## Appeal Decision

**Appeal Ref: APP/R5510/D/25/3359609**

**28 Columbia Avenue, Ruislip, Hillingdon HA4 9SU**

- The appeal is made under section 78 of the Town and Country Planning Act 1990 (as amended) against a refusal to grant planning permission.
- The appeal is made by Petra Disterer against the decision of the Council of the London Borough of Hillingdon.
- The application Ref is 59385/APP/2024/1247.
- The development proposed is a ground floor wraparound extension, a second storey side extension, internal alterations and all associated works.

Drawing Title	
Proposed Drawings	
00 @ A1	Drawn AF
2024	Checked BV
Job No. 002-3100	Rev A

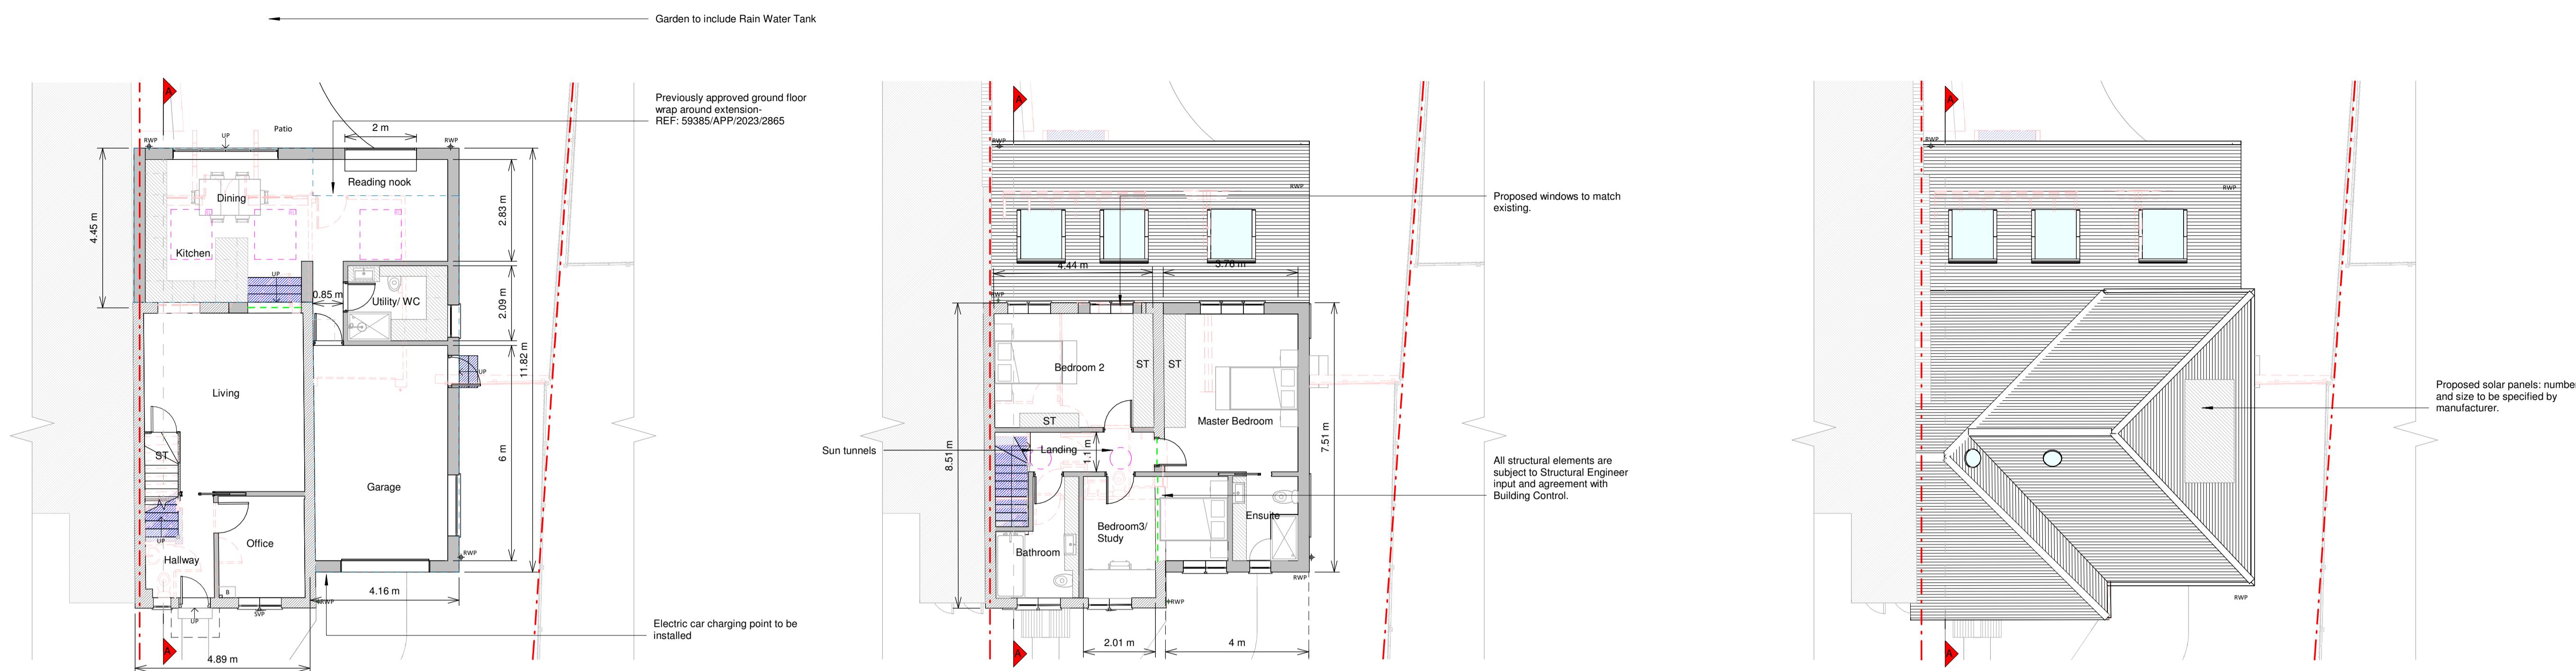
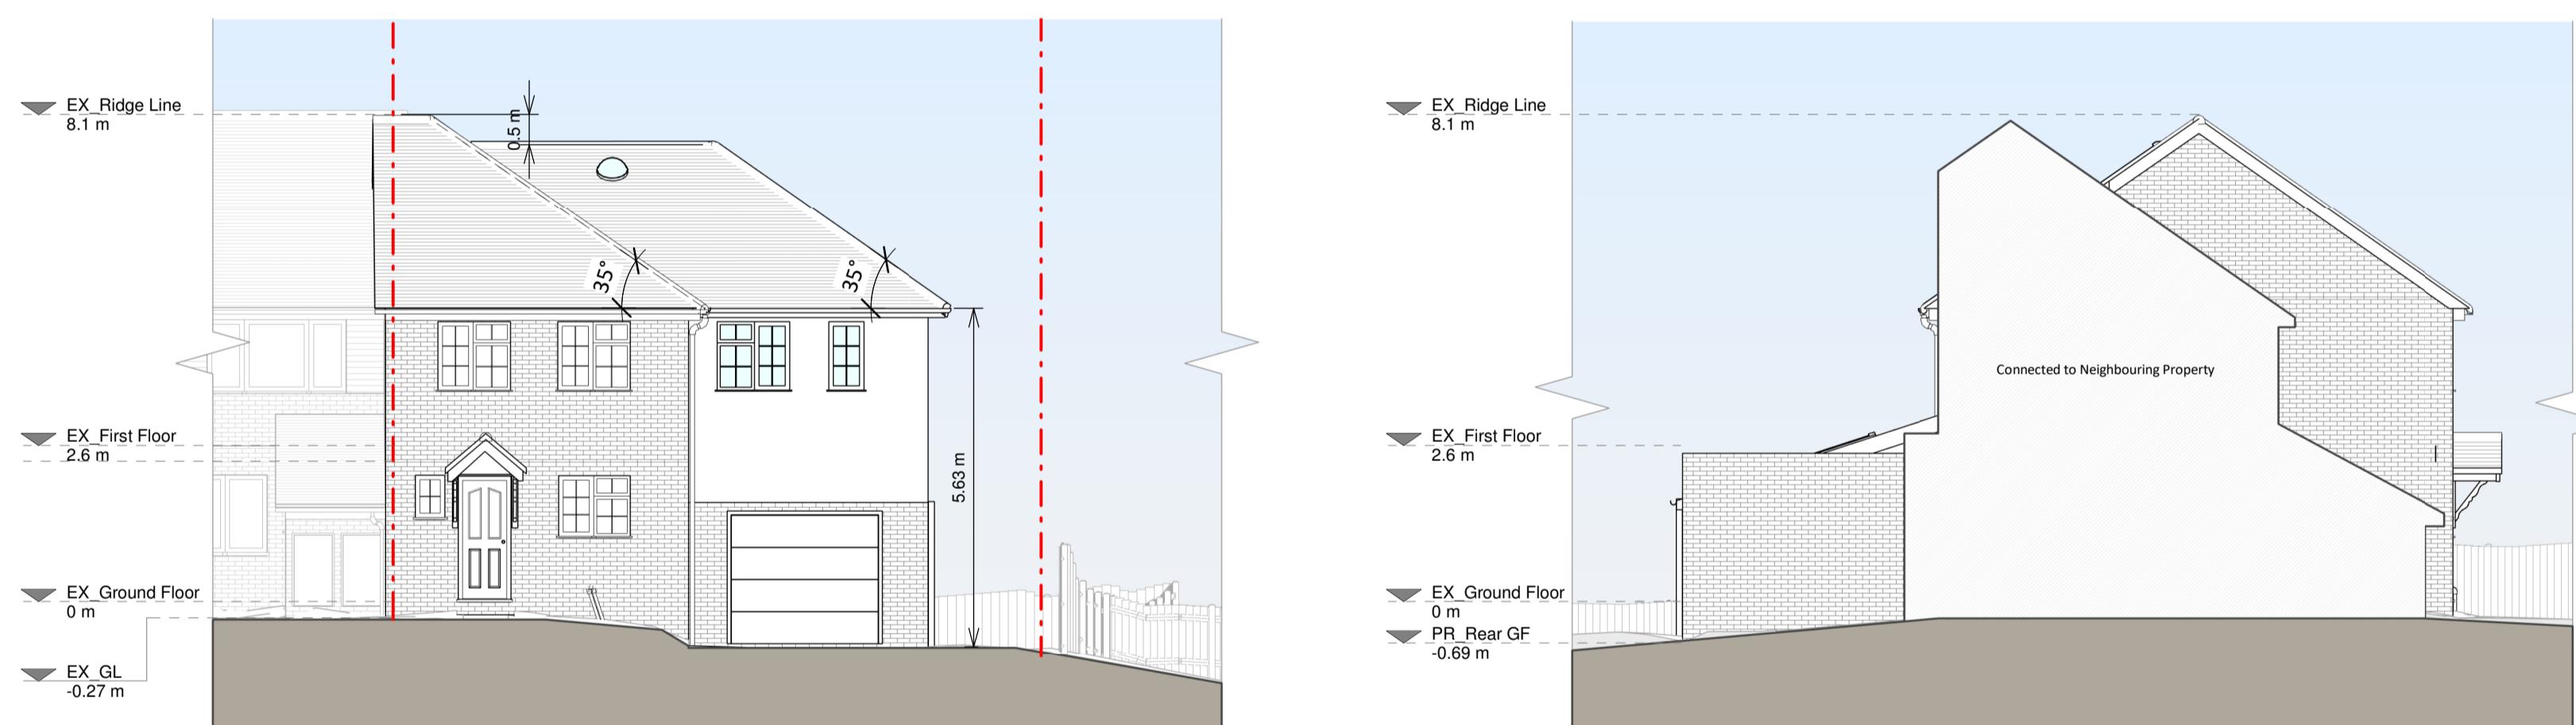
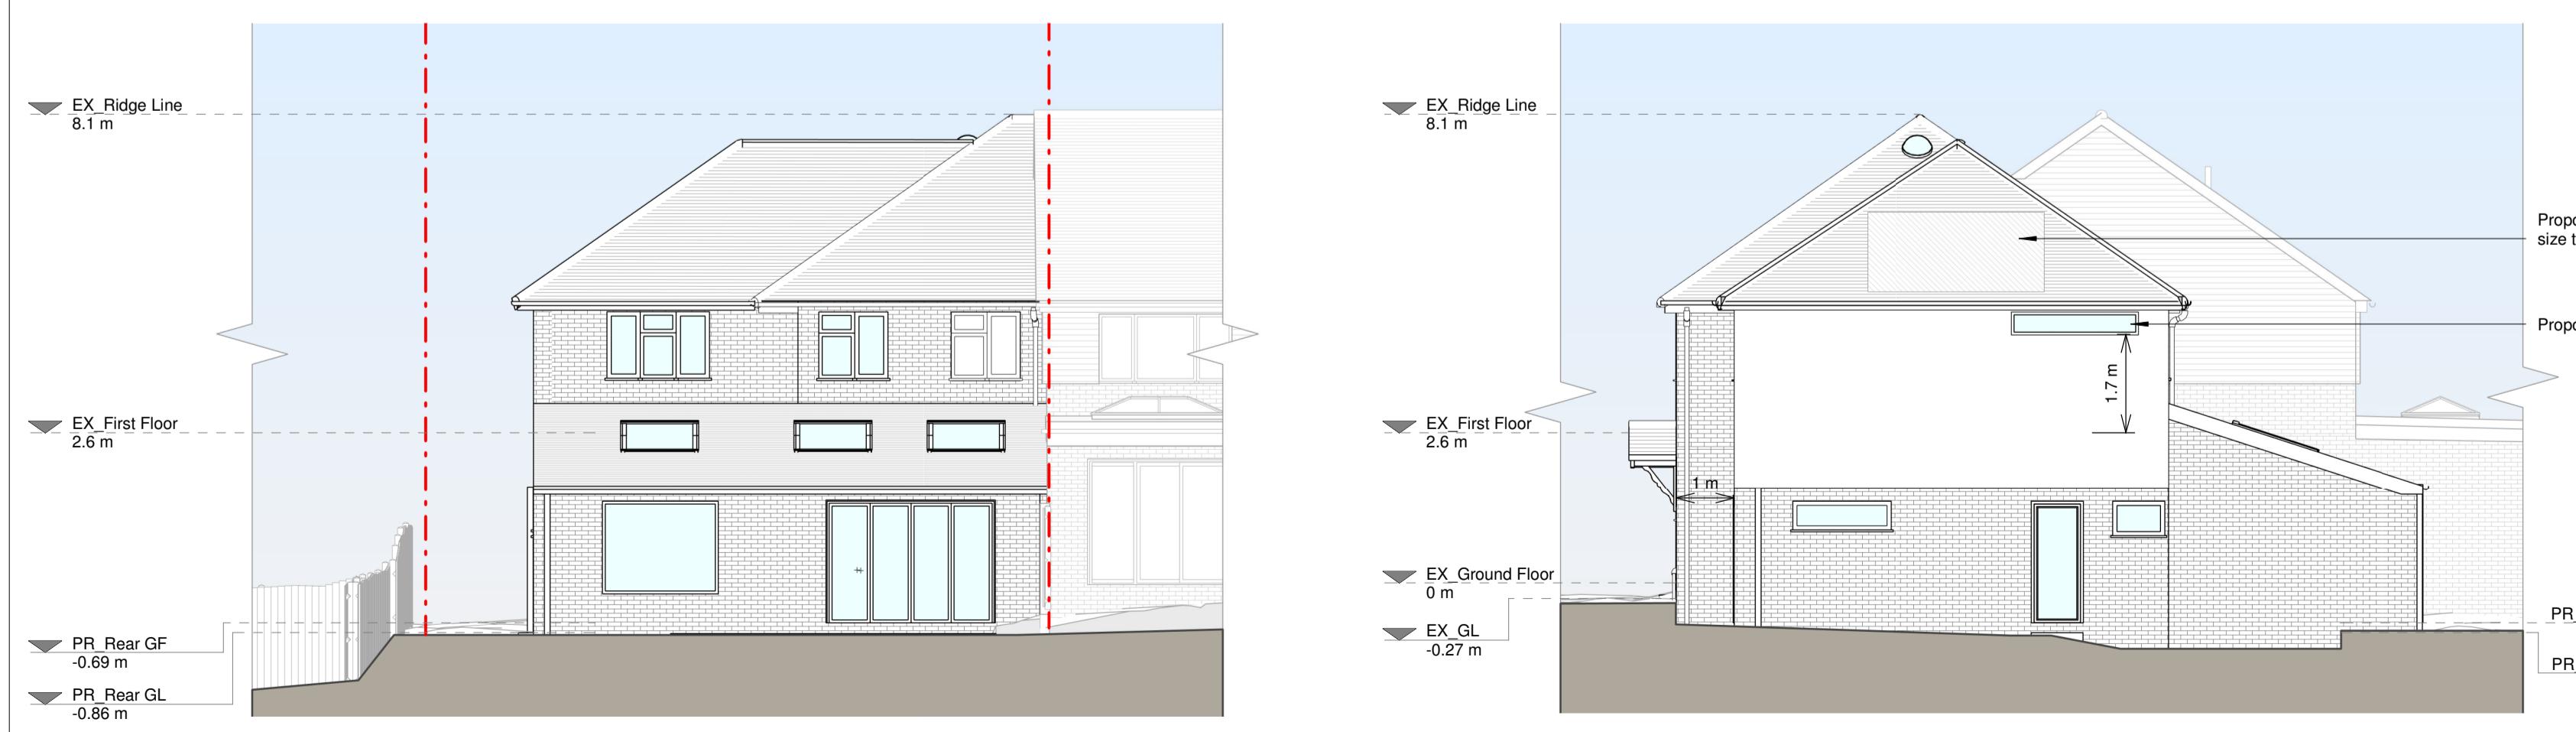
4. The proposed two storey side extension would exceed half the width of the existing property. However, it would be no deeper than the host, and its 1 metre set back on its front face, and its 0.5 metre set down at ridge level, would respect the articulation and staggered building line which are so characteristic of these terraces; and would ensure that it would appear appropriately subordinate to the host.

5. There would still be a space between the development and the side boundary, and a large gap would be retained to the nearest building on Dollis Crescent to the south. Thus, on this spacious plot, the proposal would not appear cramped. Considered along with the proposed matching materials, all these features ensure that the scheme would be assimilated into the streetscene.

7. As the proposed side extension would exceed half the width of the original property, the scheme would conflict with the requirement at Part C) i) of HLP2 Policy DMHD1. However, given my assessment above, it would nevertheless appear appropriately subordinate to the main dwelling in accordance with its Part A) iii). The scheme would not therefore conflict with the development plan when considered as a whole.
